Application No: FG/52/22/HH
Site Address: 6 Beehive Lane Ferring BN12 5NL
Description of works: Erection of two storey front extension with front canopy, single storey side and rear extension and extension of loft to habitable use including the installation of 1 x side dormer.

Thank you for your internet representation made on 19th April 2022 which has been recorded as an objection with the comments as follows:

Drawing
Proposed Elevations

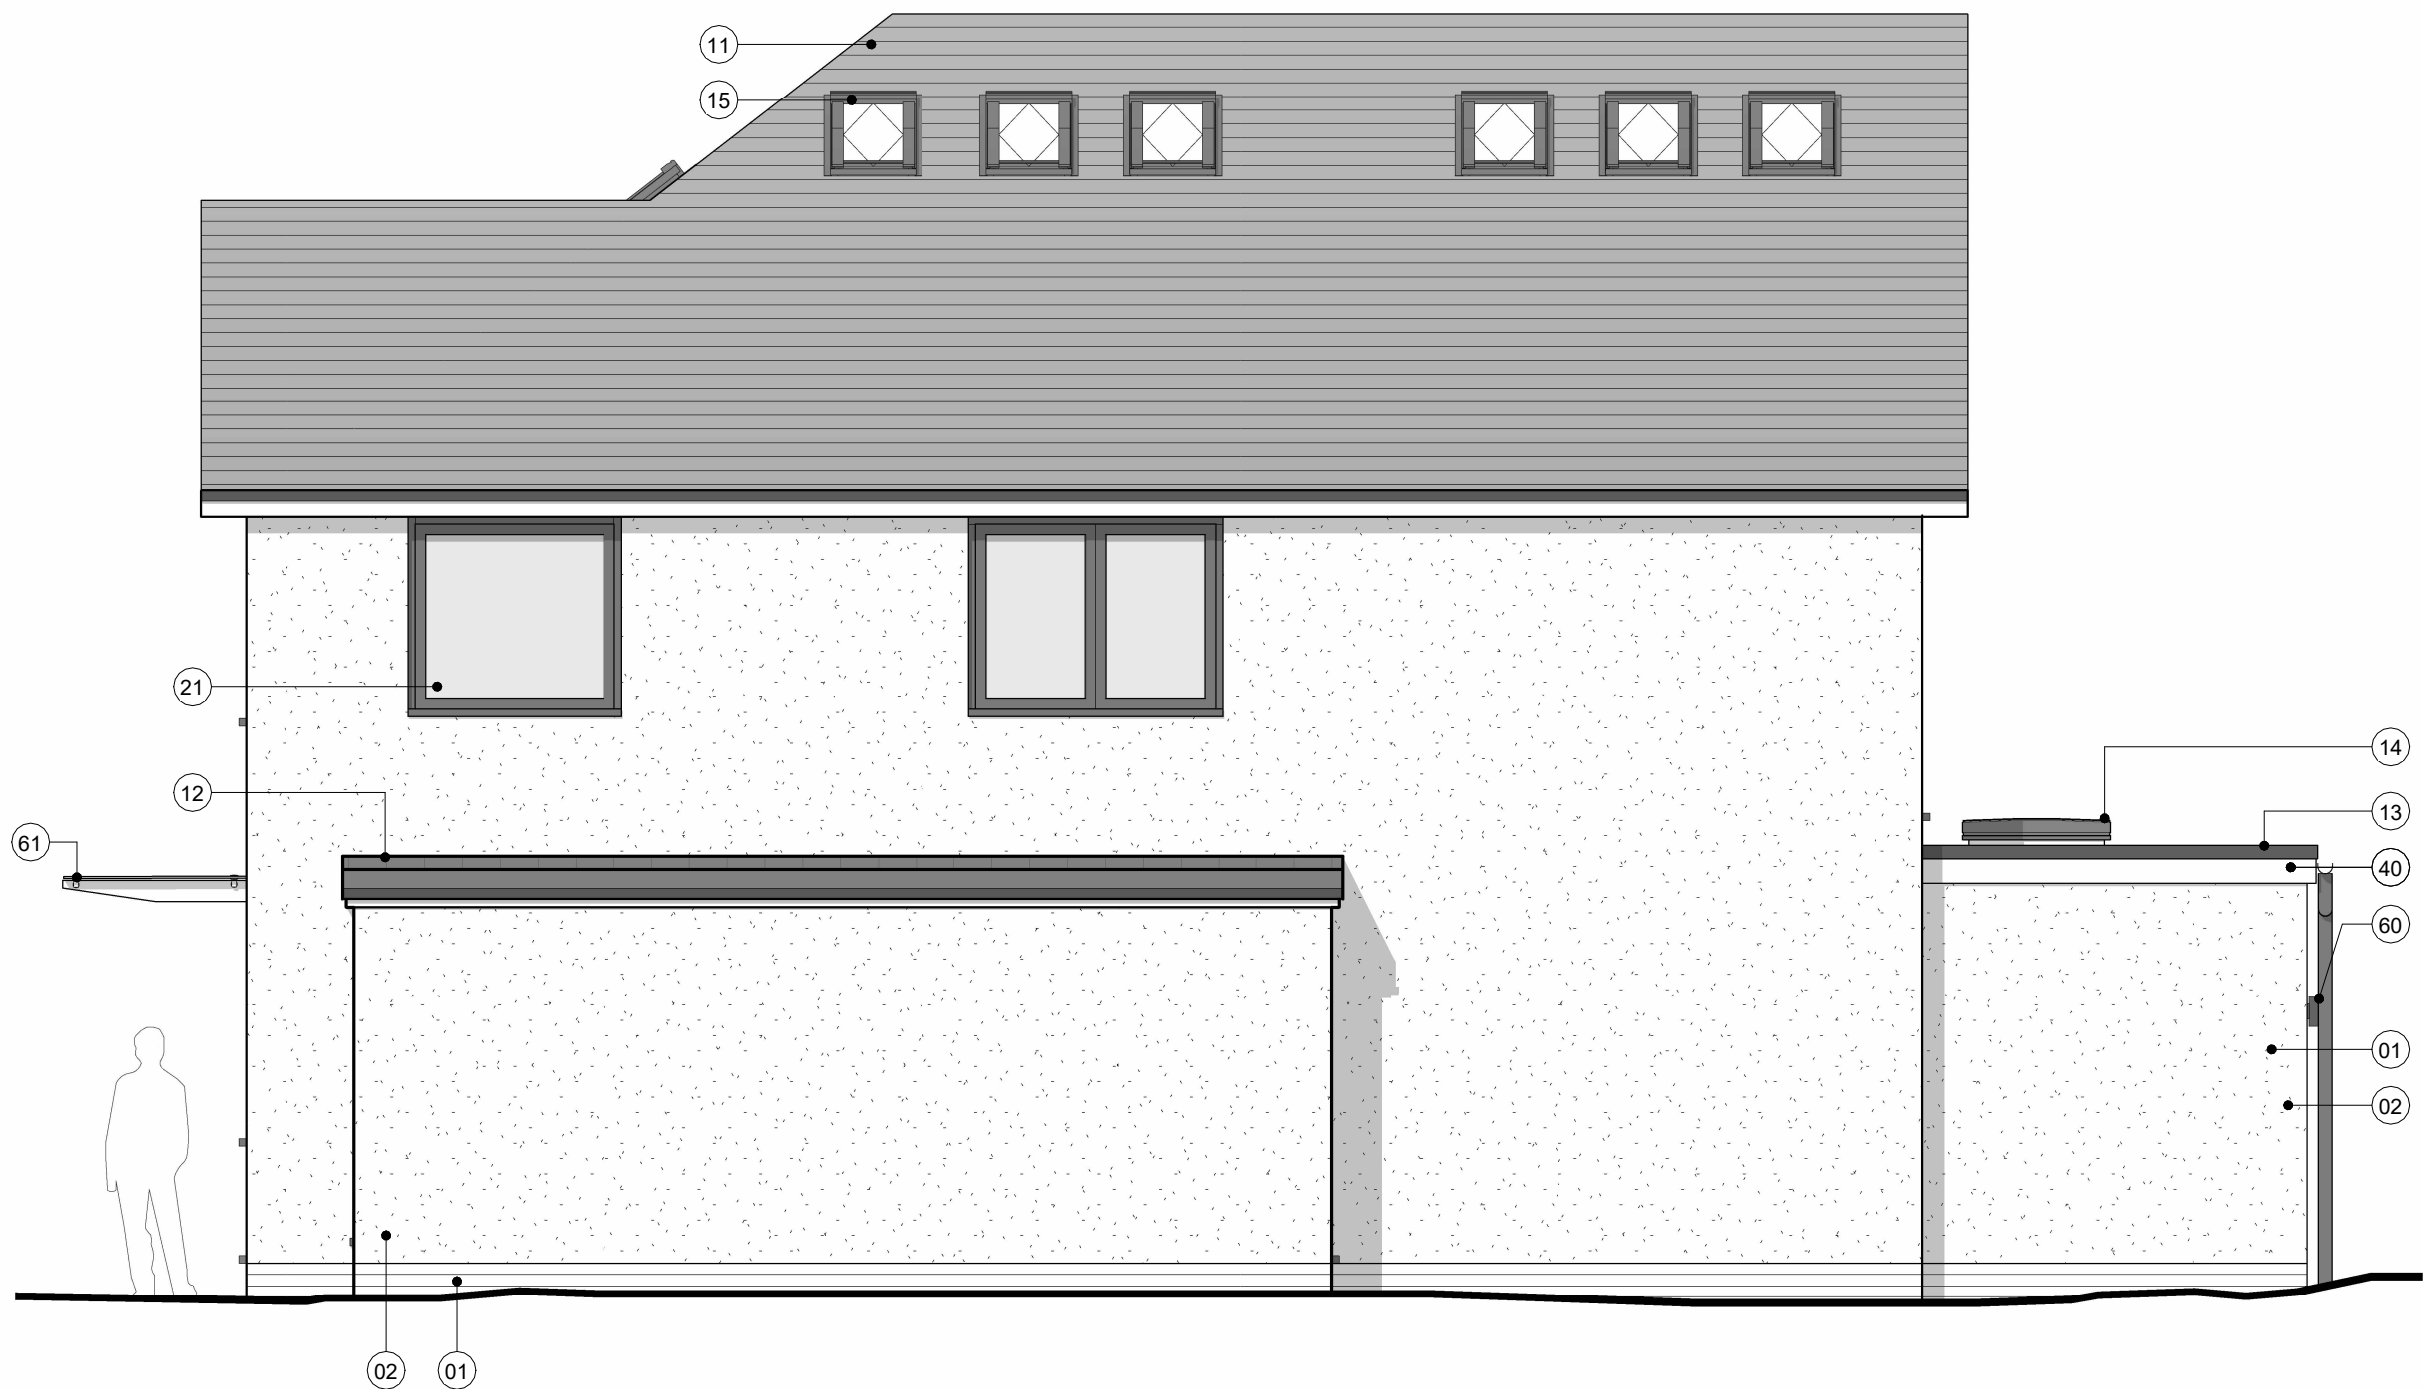
Ferring Conservation Group objects to this gross overdevelopment. It is overbearing on its neighbours and intrusive in the street scene.

It is completely out of character for this road, and for Ferring, which has hardly any three-storey buildings. The Local Plan requires that development respects or enhances the environment in which it is placed. This clearly does neither.

It also requires extensions to be subservient to the host building. This extension is dominant, not subservient. Please refuse this ugly and inappropriate extension, - Ed Miller (Secretary, Ferring Conservation Group)
